# Rezoning Transportation Analysis

Petition Number: 2020-150

General Location Identifier: Tax ID: 02508104

## Revision Log:

RZ1.0

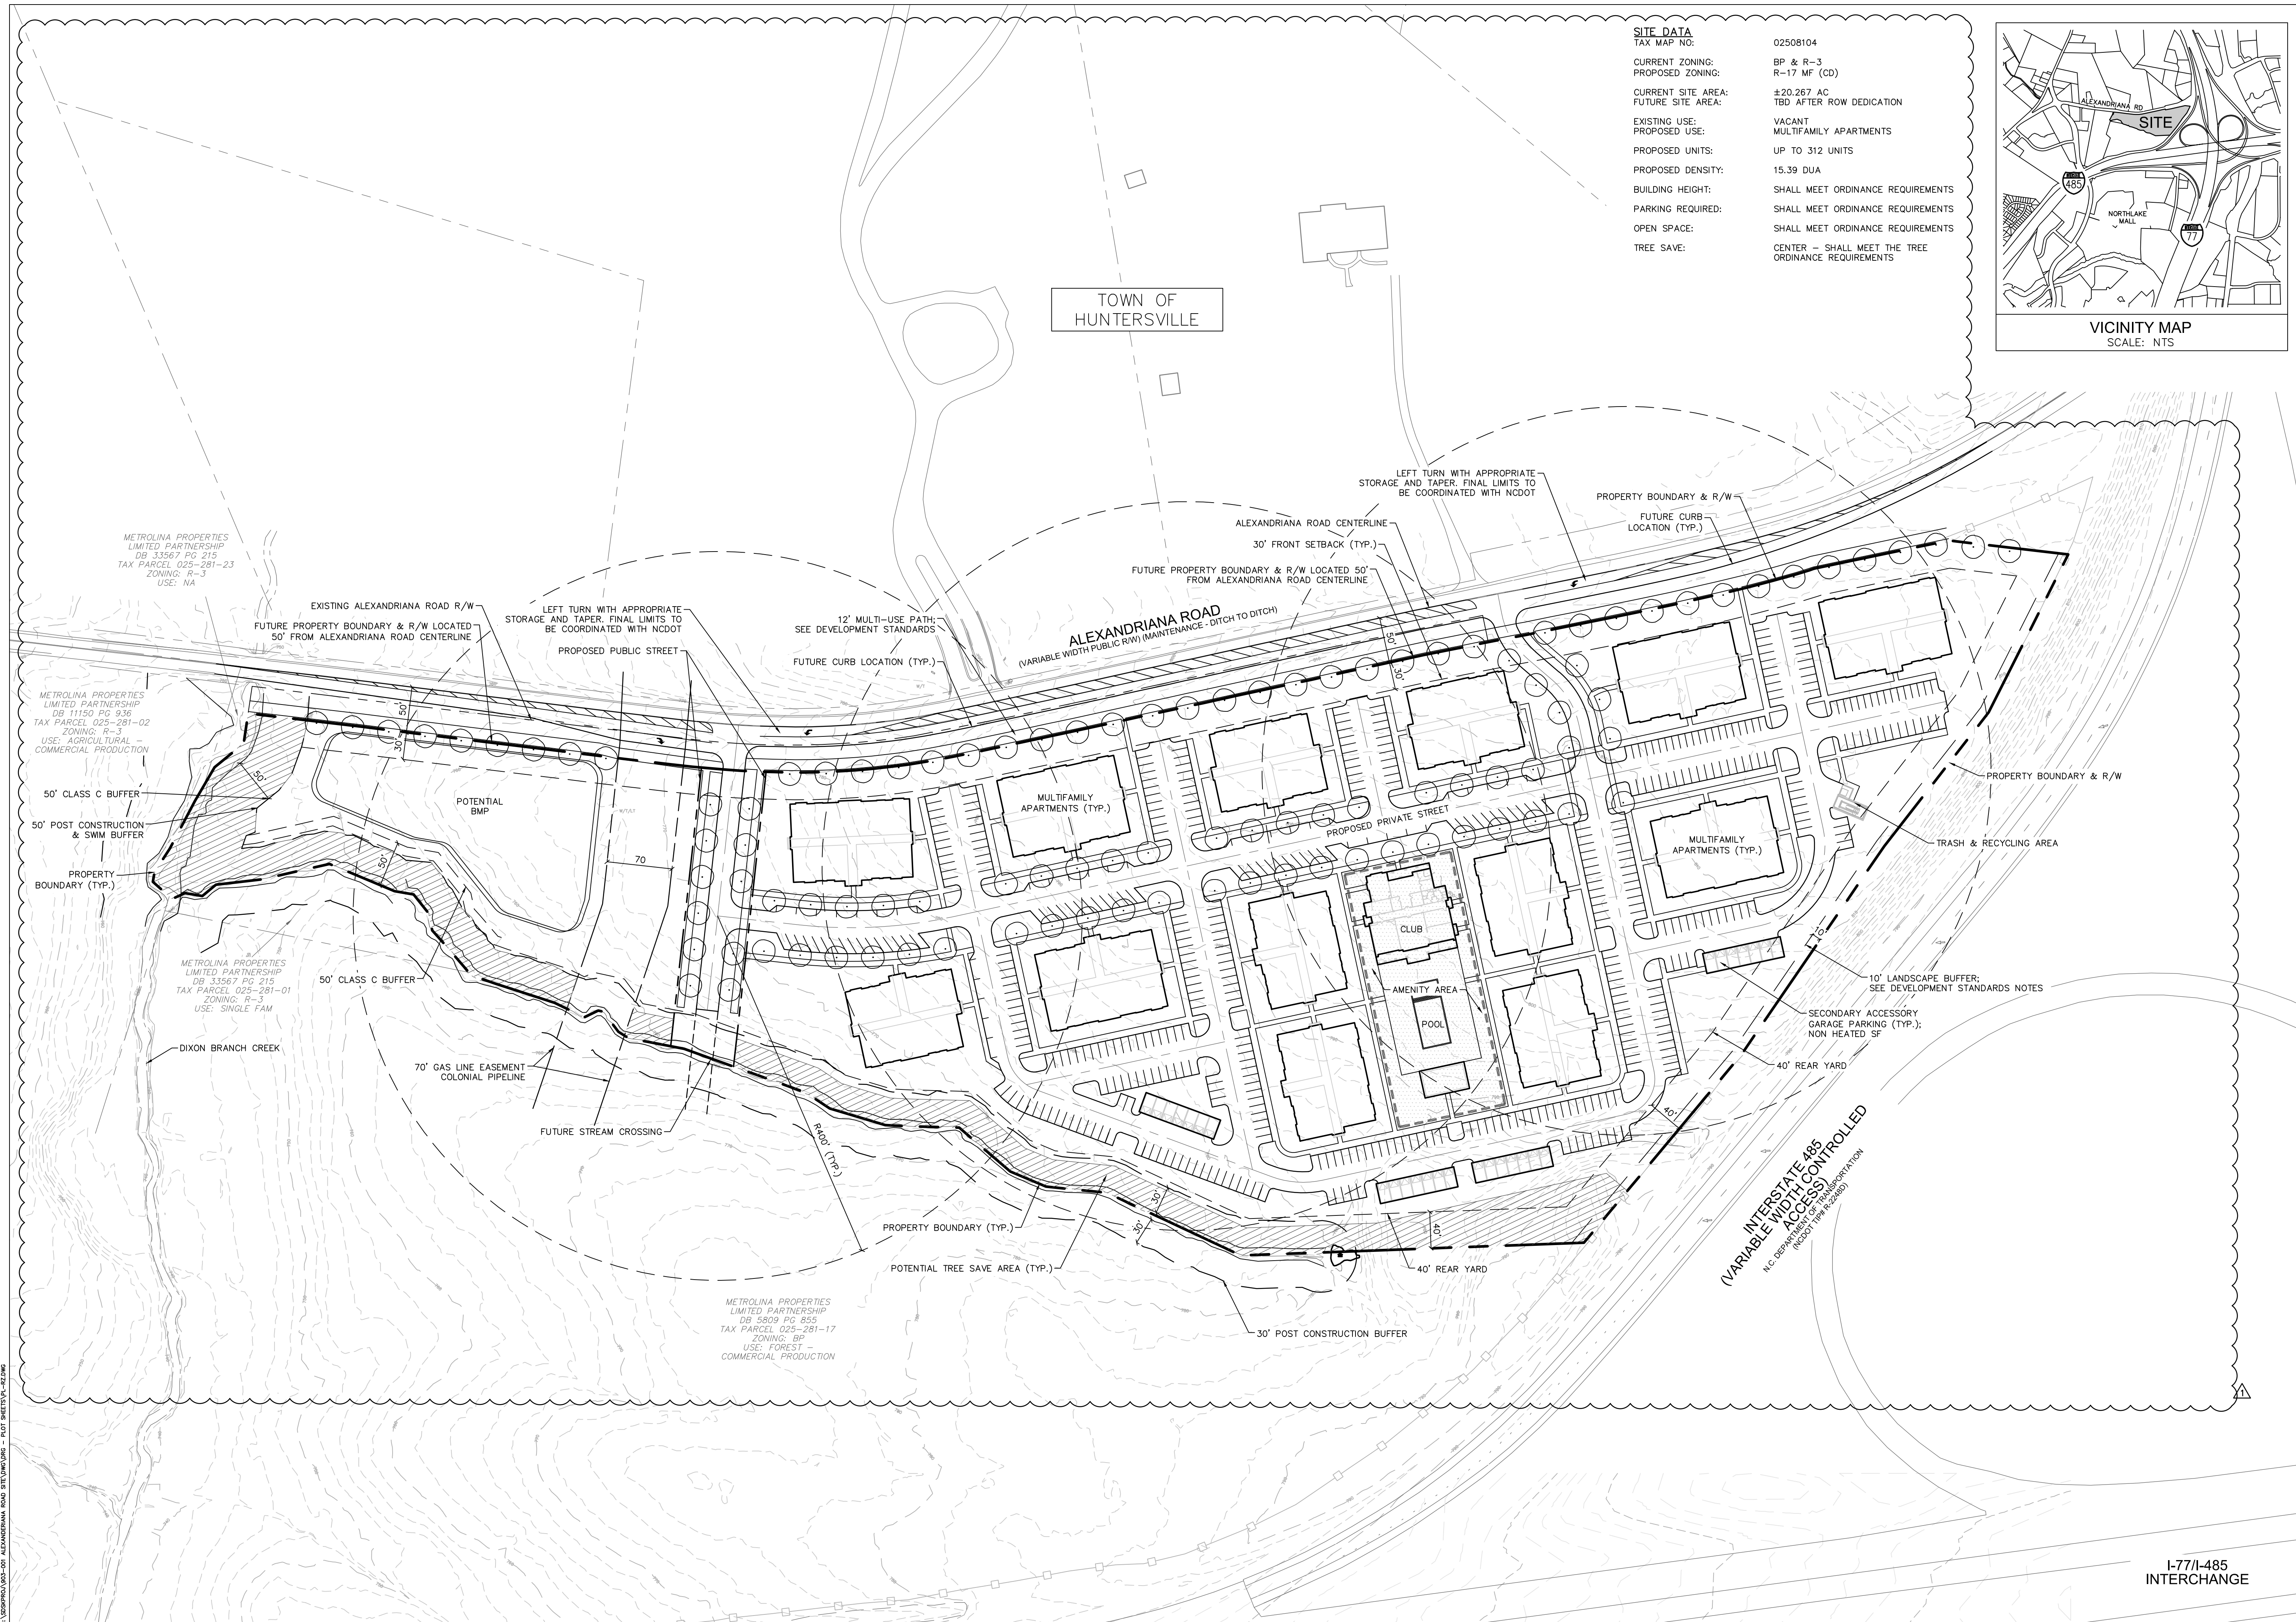
1. ~~Outstanding~~ (site plan dated 12.14.20) ~~Curbline:~~

a. ~~Alexandriana Road:~~ Location of curb and gutter needs to be installed at a location in coordination with NCDOT and CDOT. In reference to the North Lake Area Plan, the future cross section recommends a 4-lane divided facility with bike facilities. Coordinate with NCDOT (Stuart Basham) and CDOT to determine the right-of-way and asymmetric road widening needed for this future cross-section, while considering the following constraints: existing cemetery and Town of Huntersville jurisdiction limits to the north, future replacement/widening of Alexandriana Road bridge over I-77, etc. The total right-of-way width needed for this future cross-section is 100-feet.

Label and dimension the curb and gutter from the centerline for each road on the site plan.

3. ~~Outstanding~~ (site plan dated 12.14.20) ~~Revise the site plan and conditional note(s) to include the controlled-access (C/A) limits, to be provided by NCDOT.~~

4. ~~Revise the site plan and conditional note(s) to commit to construct an 8-foot planting strip and pedestrian facility along Alexandriana Road per Chapter 20 of the City Code and Charlotte BIKES;~~

CDOT requests a 12-foot shared use path. The site plan shall label and dimension both items from the back of curb and gutter and road centerline.

- ~~5. **Outstanding** (site plan dated 12.14.20) Revise the site plan and conditional note(s) to relocate the proposed access on Alexandriana Road to the private drive that is aligned with the proposed clubhouse, as permitted by sight distance constraints and NCDOT request to shift this access further away from the C/A limits.~~

- ~~6. **Outstanding** (site plan dated 12.14.20) Revise the site plan and conditional note(s) to restrict the proposed western access on Alexandriana Road to right-in/right-out, as required by NCDOT.~~
